Appeal Decision

Appeal Ref: APP/T2350/W/23/3324057

Land off Shire Lane (adj Shire Lane House), Hurst Green BB7 9QR

- The appeal is made under section 78 of the Town and Country Planning Act 1990 against a refusal to grant planning permission.
- The appeal is made by Mr Ellis Warbrick against the decision of Ribble Valley Borough Council.
- The application Ref 3/2022/0573, dated 09 June 2022, was refused by notice dated 14 December 2022.
- The development proposed is extension to the existing agricultural unit for breeding of livestock & new access road from Longridge Road and new barn.

PROPOSED ROOF & BARN FIRST FLOOR PLAN

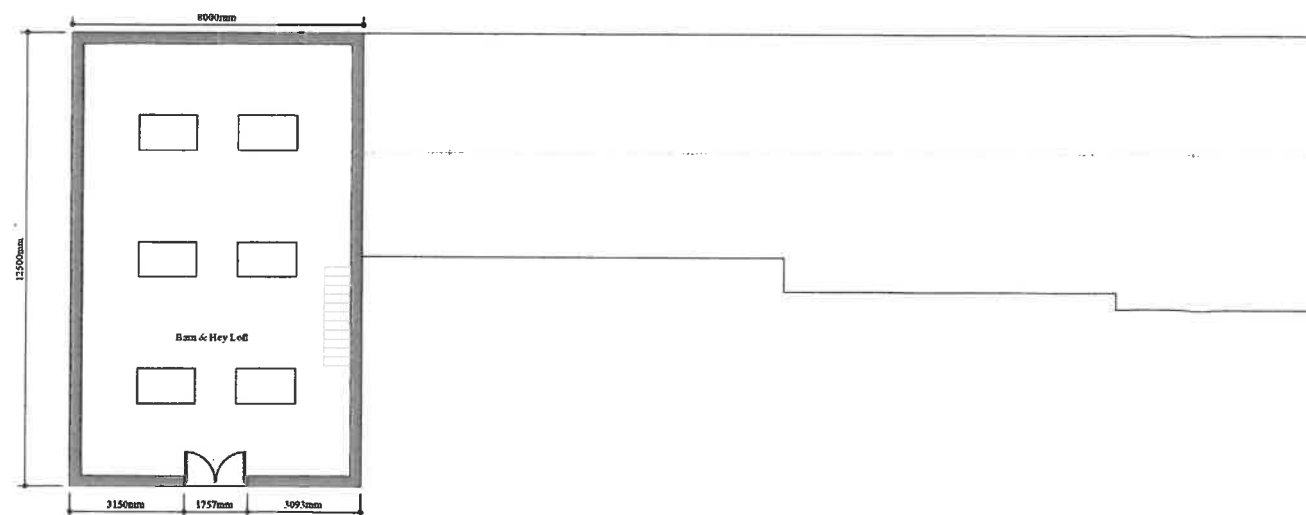
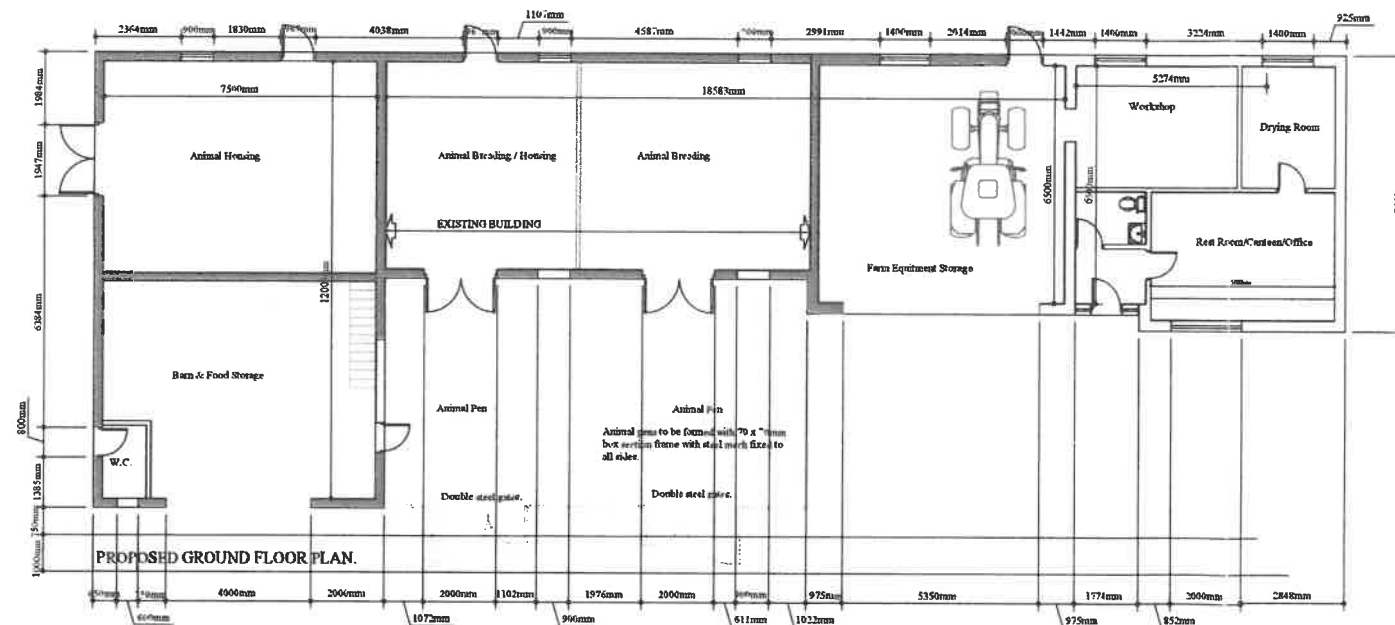
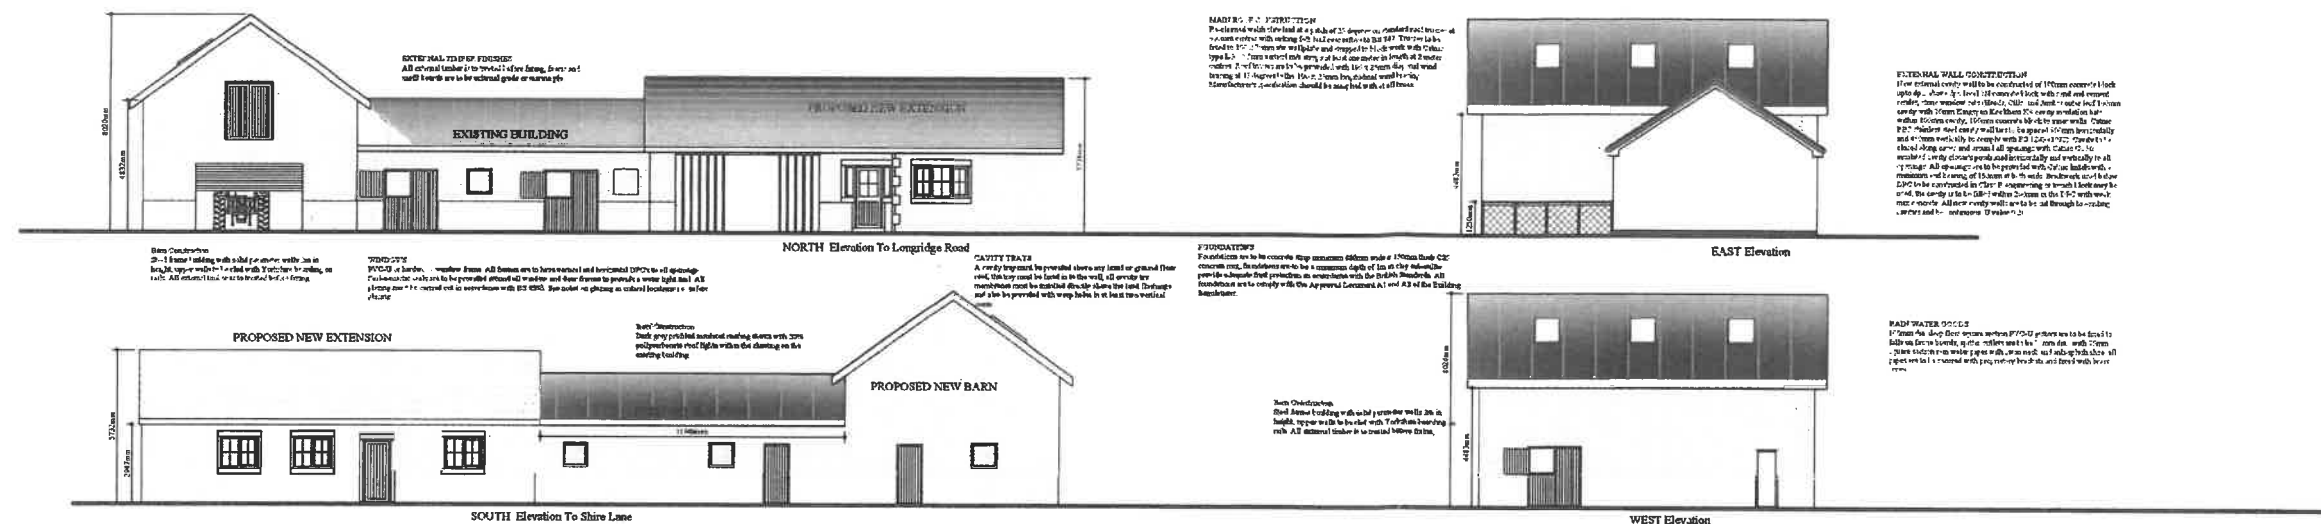
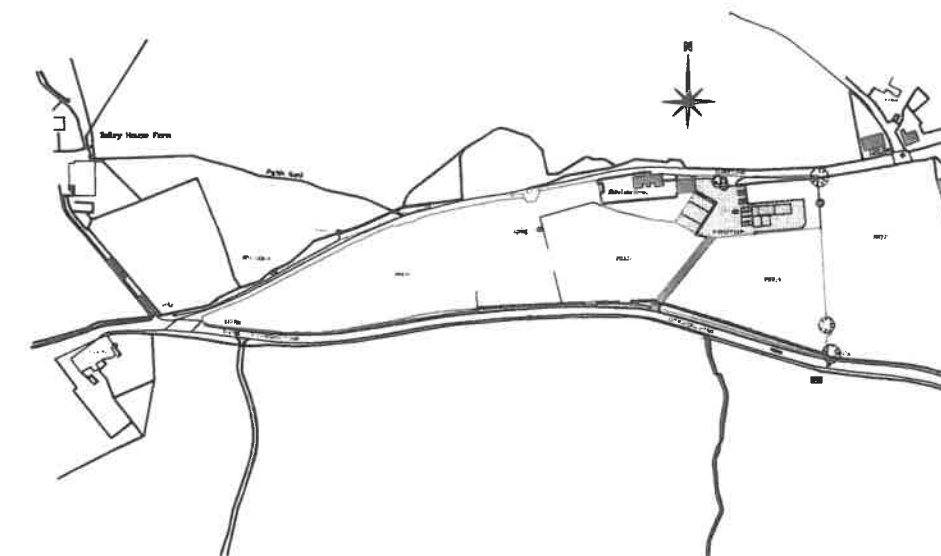
10. Notwithstanding my findings above, the proposal would change the appearance of the site through the alteration of the existing building, the introduction of a new building section and associated works. Having regard to the submitted plans, there are a number of openings to the building, including doors that have a somewhat domestic appearance. However, the proposed building would be constructed of external materials commonly found in this area and on agricultural buildings. As such, when viewed as a whole, the building would not appear as a domestic dwelling but have the general form and appearance of an agricultural building.

11. While there would be an increase in the footprint of the building, the resultant development would not be particularly harmful in landscape or visual terms, being reflective of the rural character of the area and a working agricultural landscape. The proposed development would remain situated within a dispersed cluster of existing buildings found along Shire Lane. The development would ensure that the site remains partially isolated among a remote group of buildings within the wider landscape, which is a characteristic of this part of the NL.
